RE: SADLER MINI STORAGE (D-18/D39)  
(7801 Louisiana NE)  
ENGINEERS CERTIFICATION FOR CERTIFICATE OF OCCUPANCY  
ENGINEERS STAMP DATED 2/2/2000  
ENGINEERS CERTIFICATION DATED 5/3/2001

**RE: SADLER MINI-STORAGE (D18-D39). GRADING AND DRAINAGE PLAN FOR BUILDING PERMIT AND SO#19 PERMIT APPROVALS. ENGINEER'S STAMP DATED AUGUST 9, 1999. SUPPLEMENTAL DATA LETTER DATED OCTOBER 4, 1999.**

***RE: SADLER MINI-STORAGE (D18-D39). DRAINAGE PLAN FOR Rough GRADING  
PERMIT APPROVAL. ENGINEER'S STAMP DATED APRIL 8, 1999.***

**RE: SADLER MINI-STORAGE (D18-D39). GRADING AND DRAINAGE PLAN FOR  
BUILDING PERMIT AND SO#19 PERMIT APPROVALS. ENGINEER'S STAMP  
DATED FEBRUARY 2, 2000.**

REV.	DATE	DESCRIPTION
1	02/28/00	PROJECT TITLE: Sadler Mini-Storage Louisiana at Ranchitos Albuquerque, NM
2	02/28/00	SHEET TITLE: Drainage Plan
3	02/28/00	DRAWN BY: [Signature]
4	02/28/00	CHK'D BY: [Signature]
5	02/28/00	DATE: 02/28/00
6	02/28/00	D1

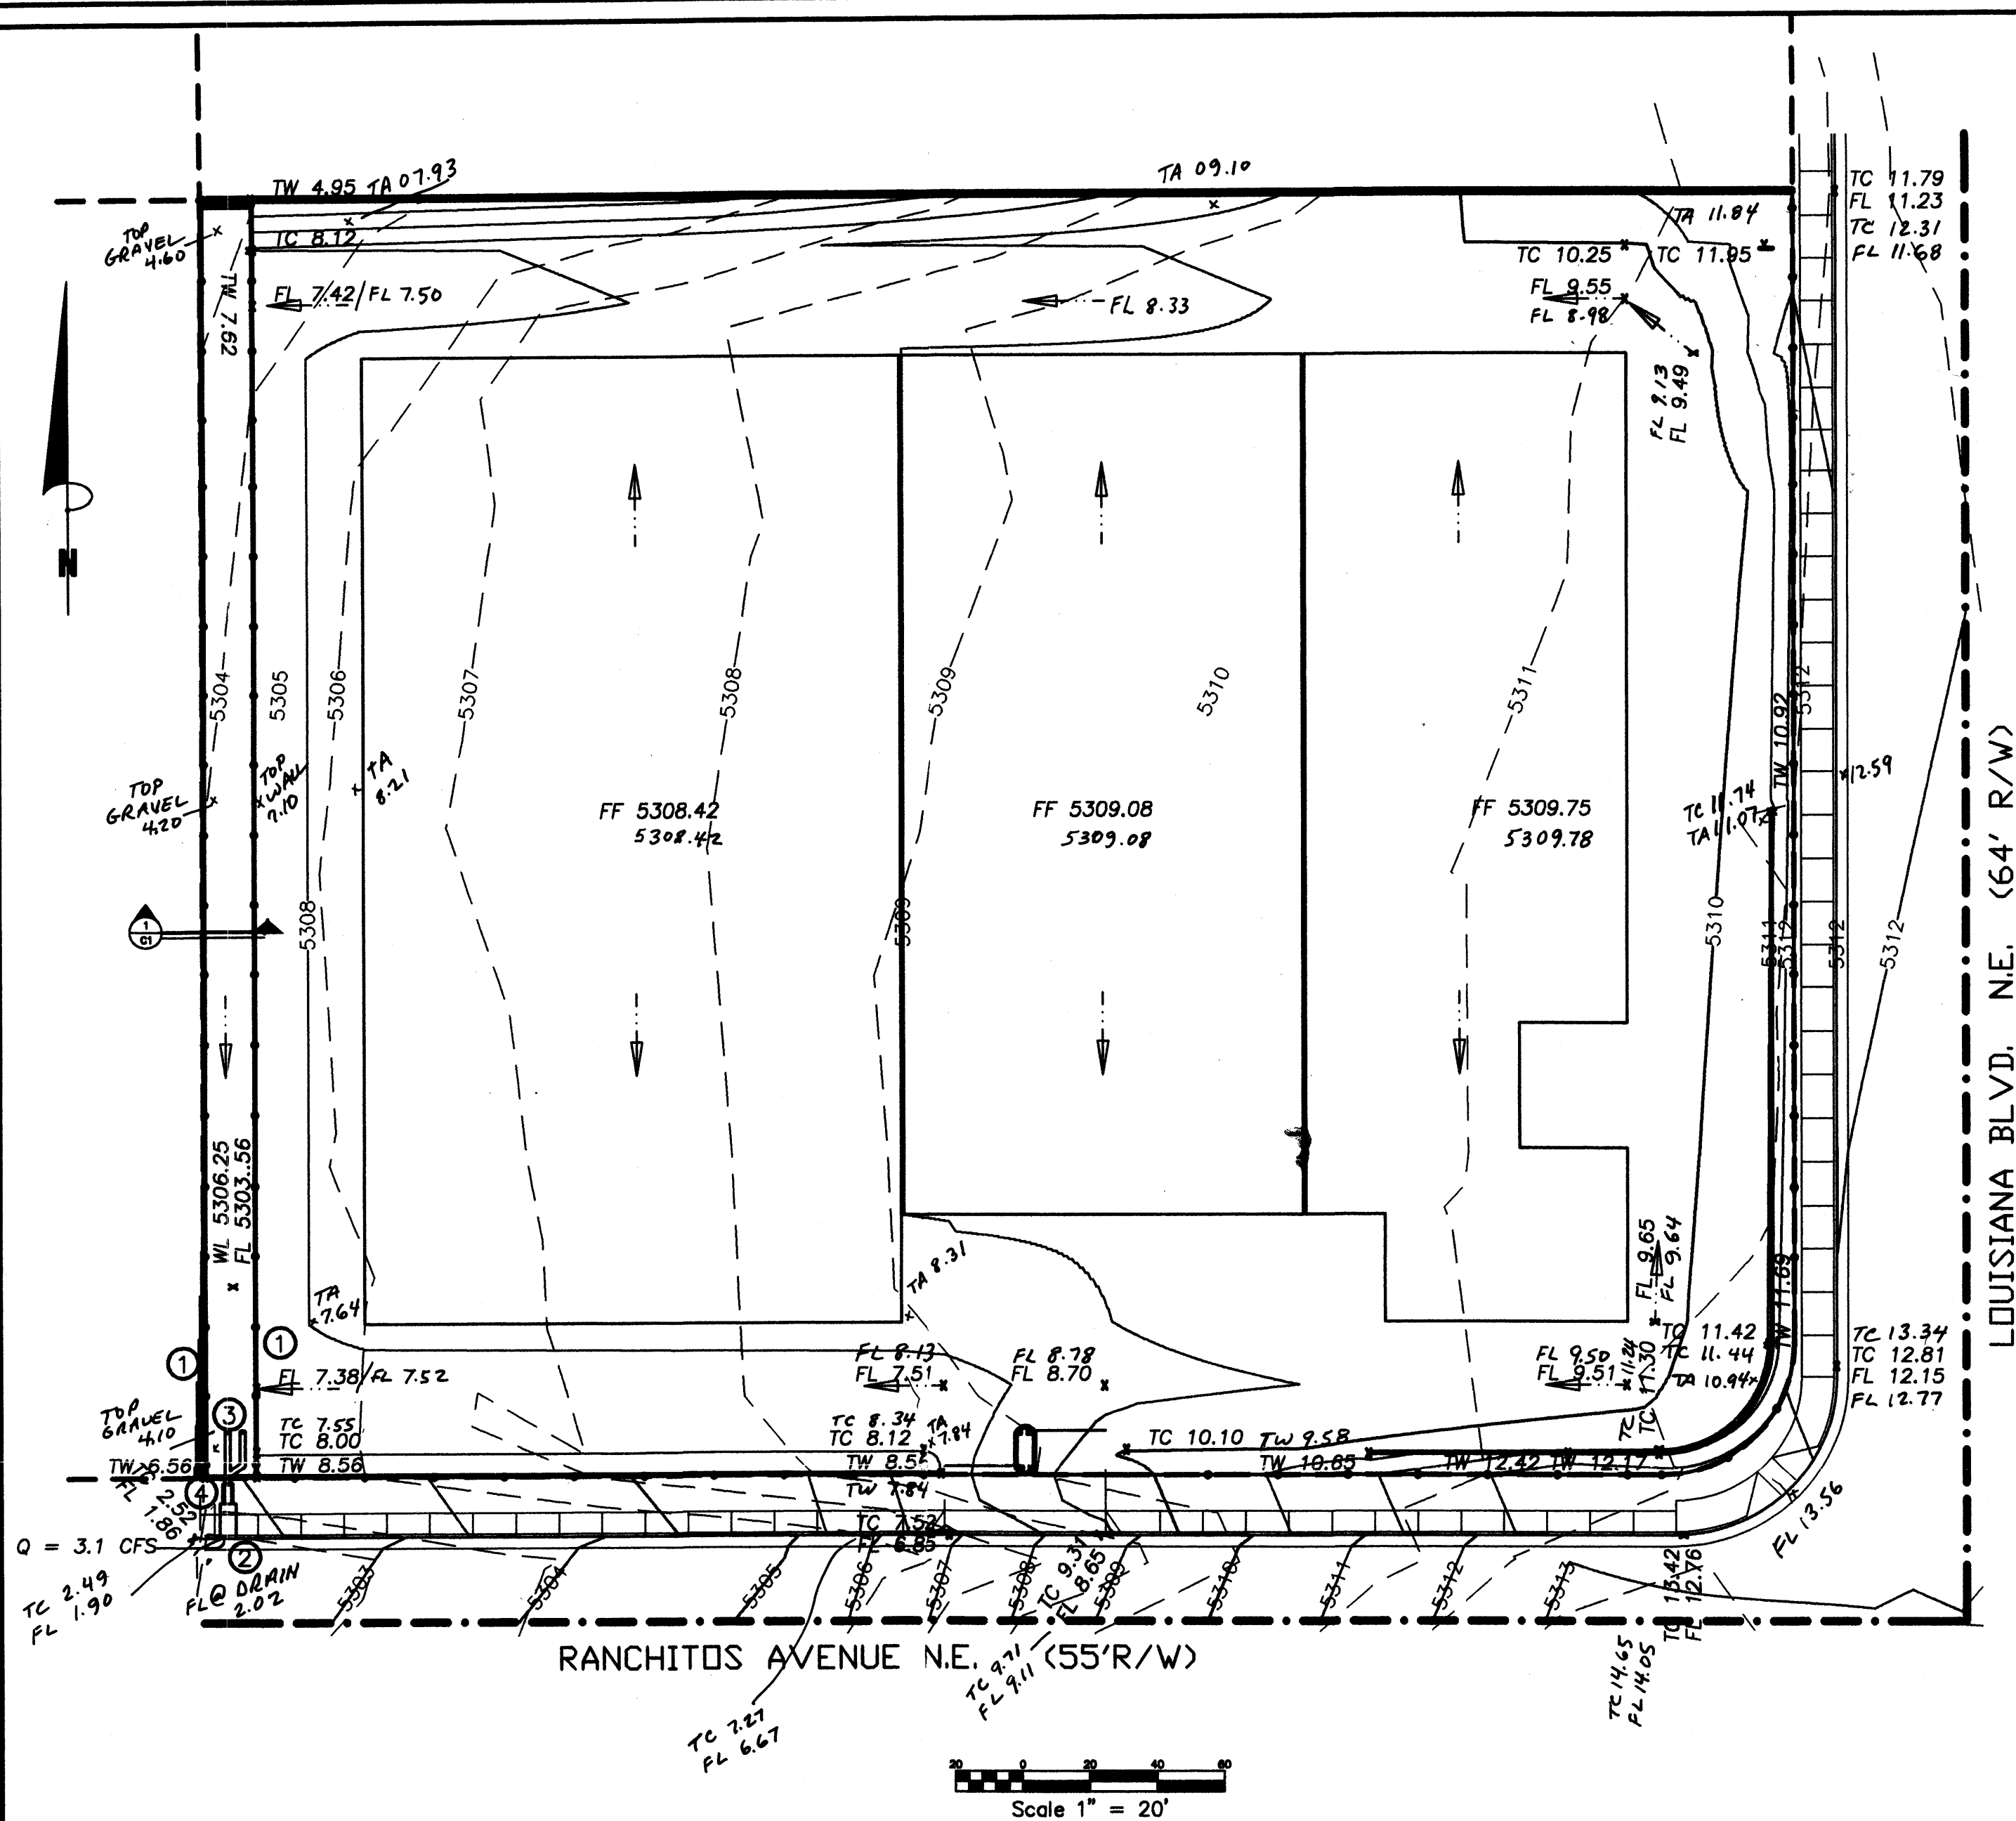
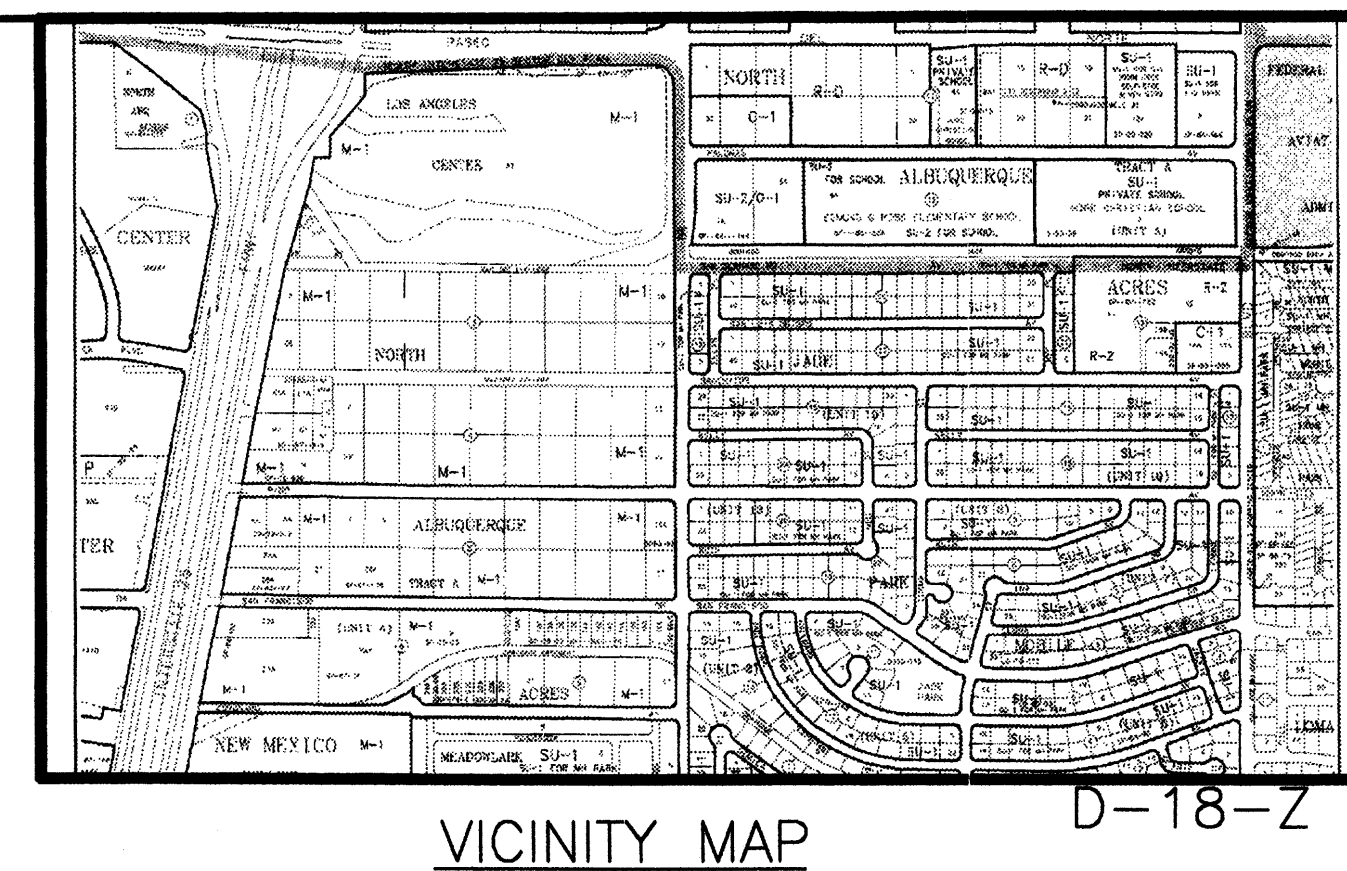
Based on the information provided on your February 9, 2000 submittal, the above referenced project is approved for Building Permit and for SO#19 Permit. The facility has been completely reconfigured since the previous submittal of August/October 1999. Indicate the direction(s) of the roof drainage. Show outlet control calculations. Clarify language regarding detention pond(s).
